<b>Title</b>	Plant Noise Commissioning		
<b>Project</b>	Domino's, Honiton		
<b>Reference</b>	2881.NT.1.1	<b>Author(s)</b>	BHo
<b>Date</b>	26 January 2024	<b>Reviewer</b>	FD

### Summary

CLIENT <b>THE MSG GROUP</b>		
PROJECT 86 High St, Honiton, EX14 1JN		
TITLE <b>PROPOSED ELEVATIONS</b>		
SCALE @ A1 1:50	DRAWN BY M W	DATE 22.06.23
DRAWING No <b>DB500- A506</b>	REVISION <b>B</b>

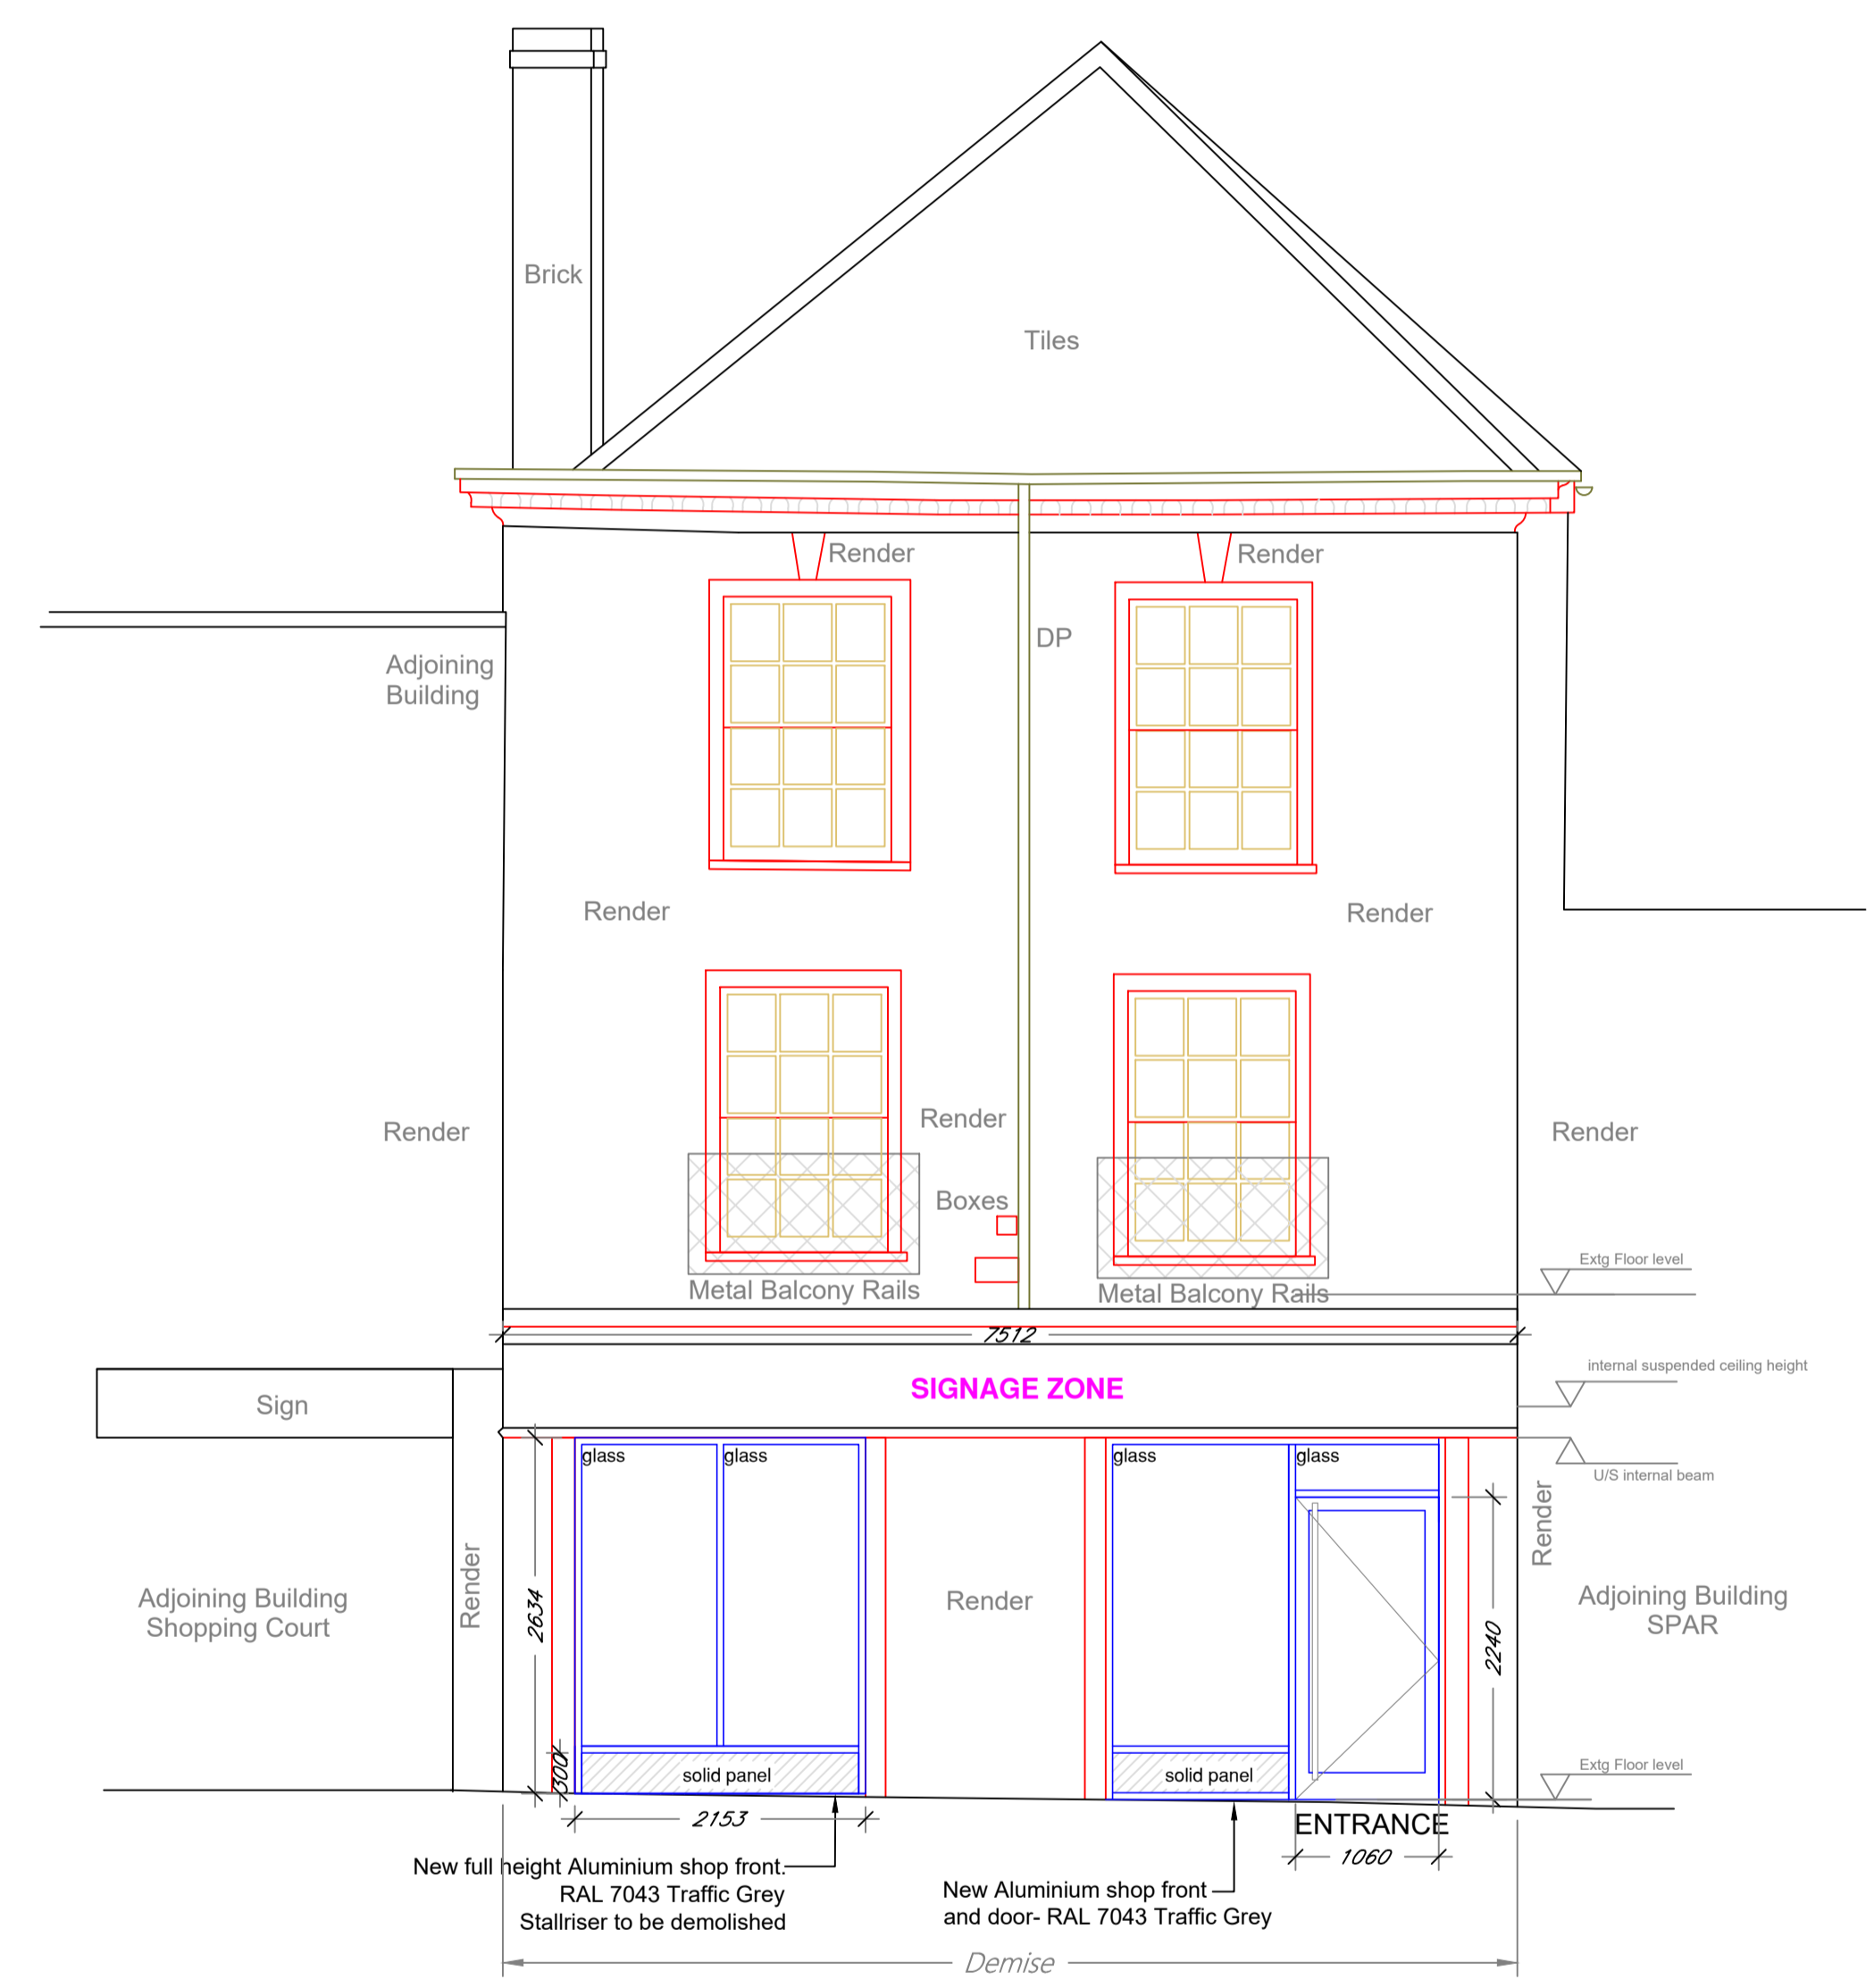
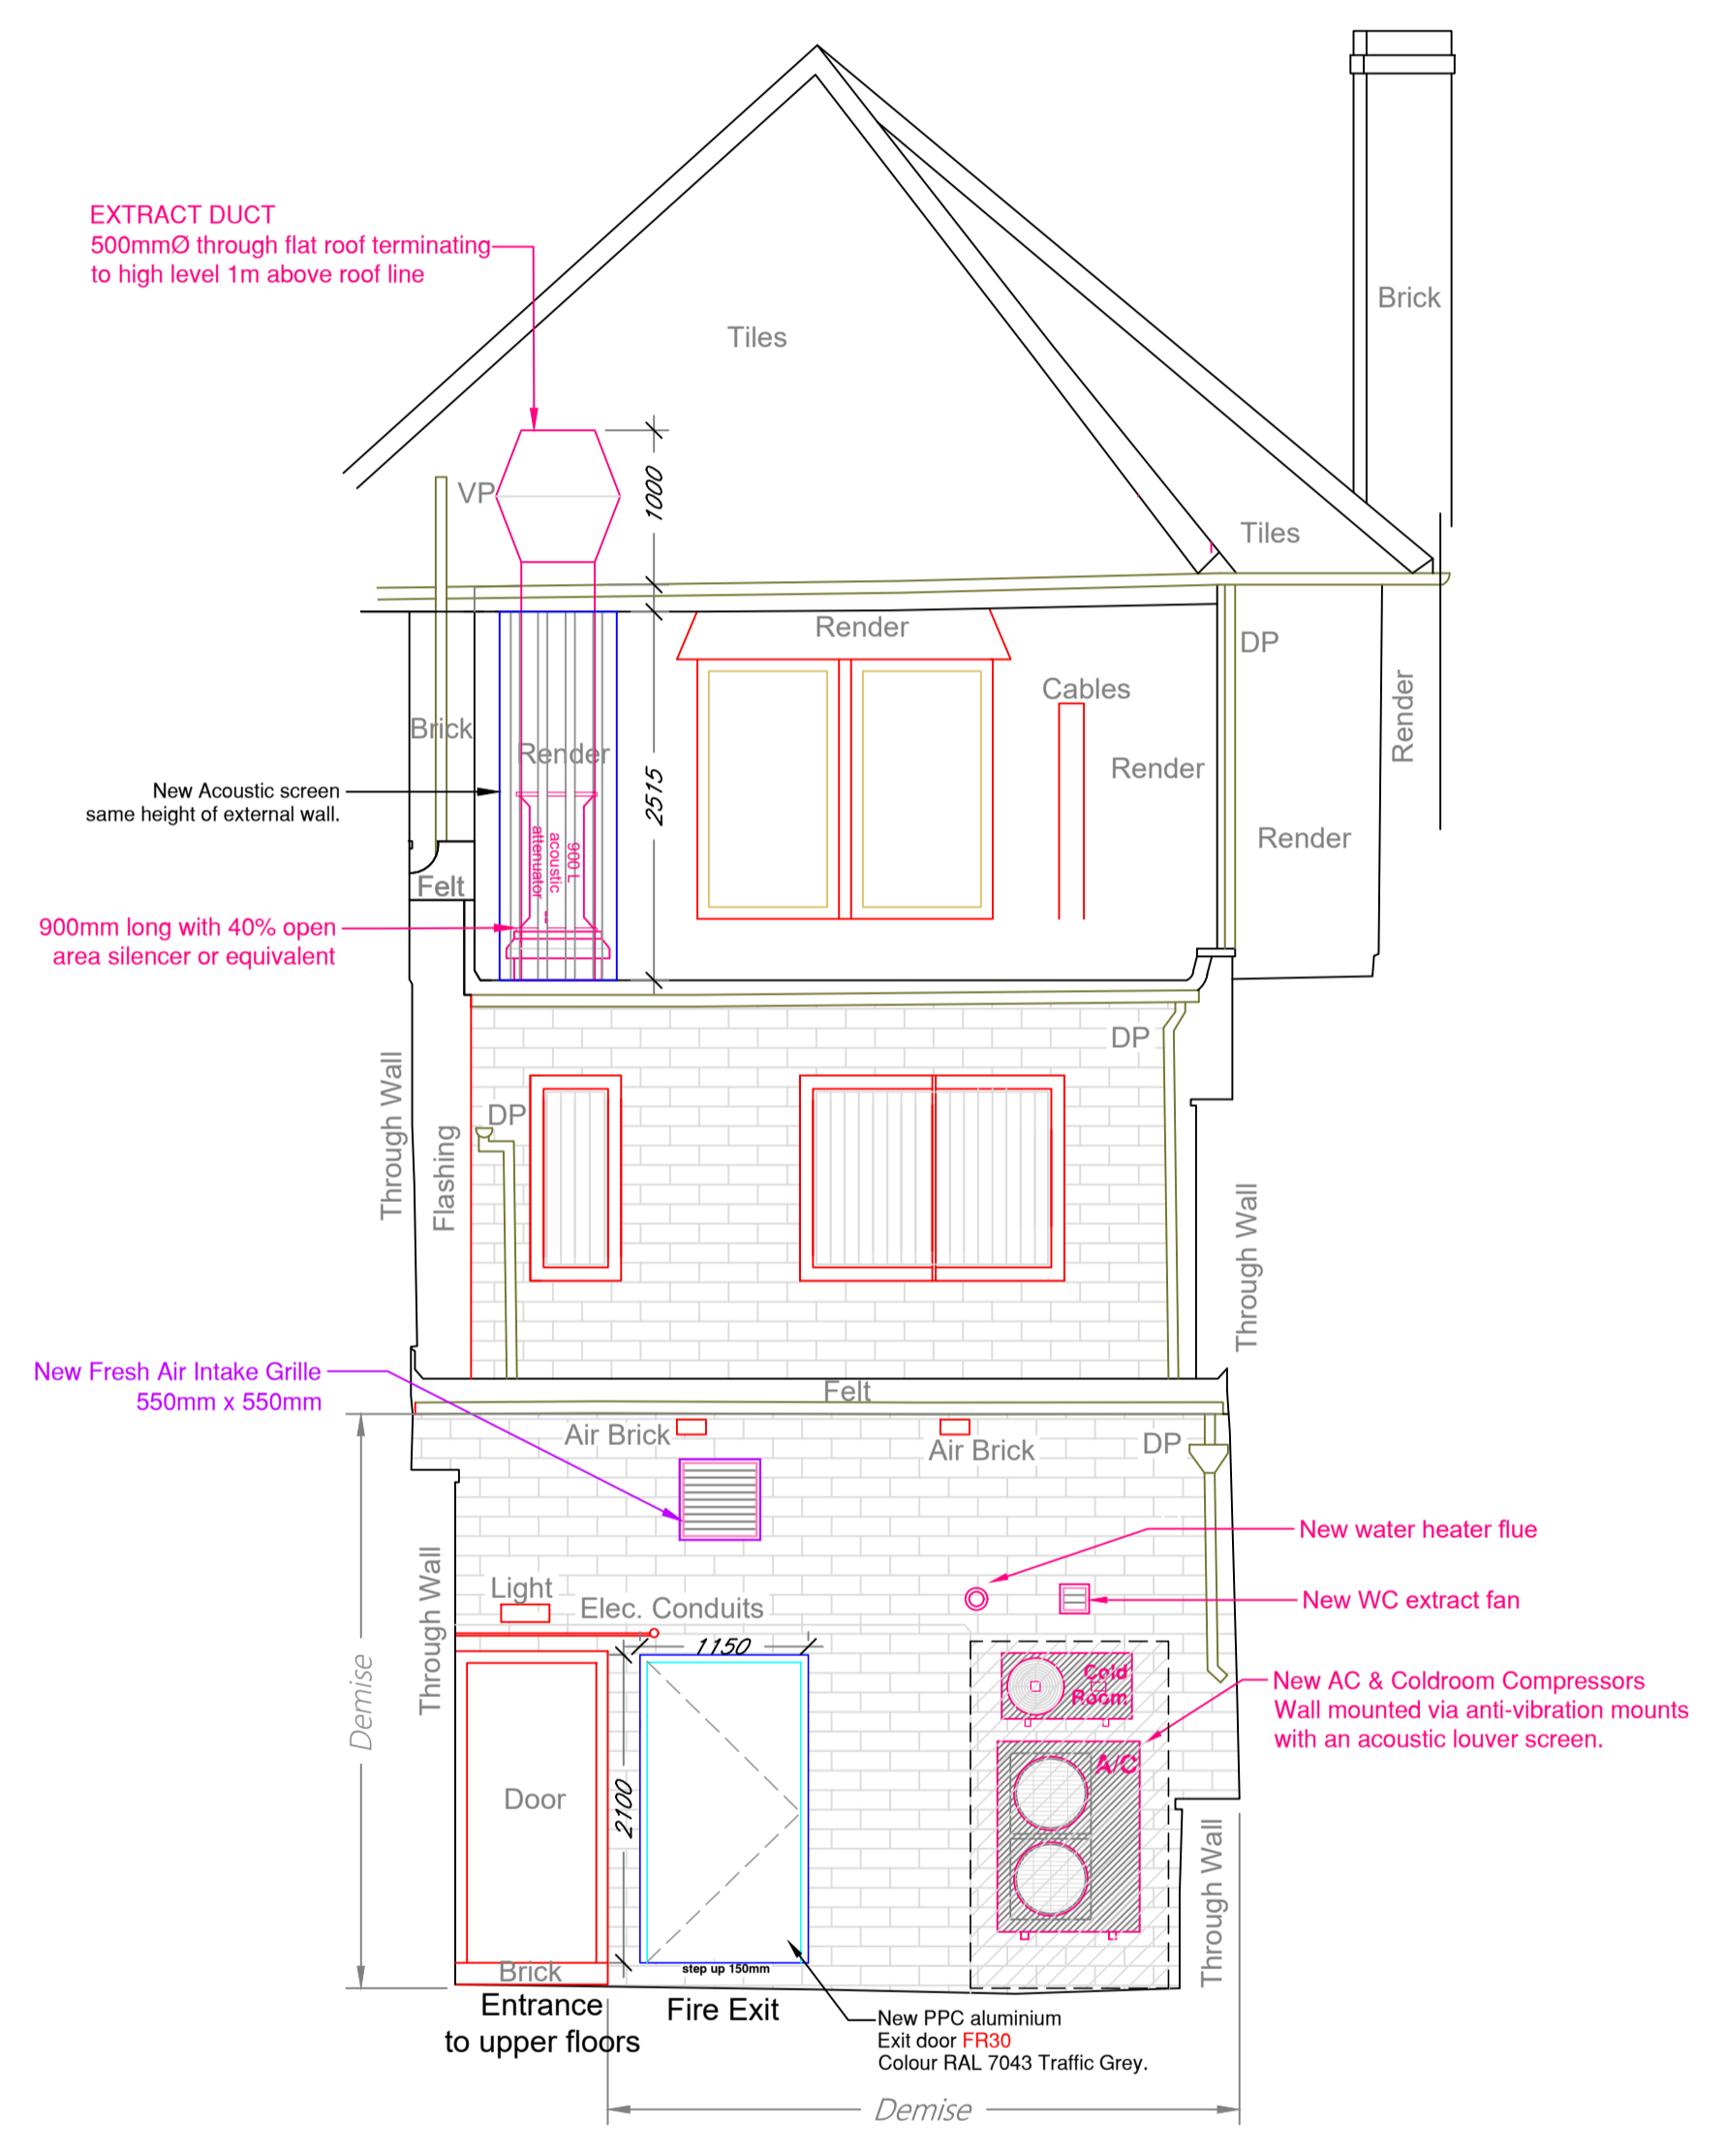
5. It is understood that the installed extract fan is different to that detailed within the original assessment and includes an in-duct attenuator.

14. It is understood that an atmospheric side in-duct attenuator is installed in the extract fan duct run. This attenuator has a length of 900 mm and 43% free area with a melinex faced coating.

15. In addition to this, more attenuation will be required. This can either be done by adding an additional attenuator or by replacing the existing attenuator of the extract fan duct run.

16. The necessary insertion losses for each attenuator are set out in **Table 1** below; these insertion losses outlined within the table must be achieved as a minimum.

Attenuator	Mitigation Type	Equipment	Minimum Required Insertion Loss (dB) at octave band centred frequency (Hz)							
			63	125	250	500	1k	2k	4k	8k
Additional	In-duct	Extract	5	8	14	15	15	8	6	4
Replacement	In-duct	Extract	8	13	26	32	35	25	19	14

17. To provide guidance on selecting and allowing for such mitigation, we would expect an attenuator 900 mm long and with 47% open area to be suitable to achieve the losses for the additional attenuator. We would expect an attenuator 1200 mm long and with 33% open area to be suitable to achieve losses for the replacement attenuator.

18. Installed attenuators should have a melinex coating for cleaning purposes. It is again noted that the insertion losses set out above are the requirement, not the example sizes or free areas.

19. In-duct silencers should be mounted internally, to avoid break out noise from the silencer casing, and as close to the fan as practicable.

20. Any pressure drops from the attenuators (or the atmospheric duct termination grille) should be limited to 40 Pa to avoid regenerated noise.
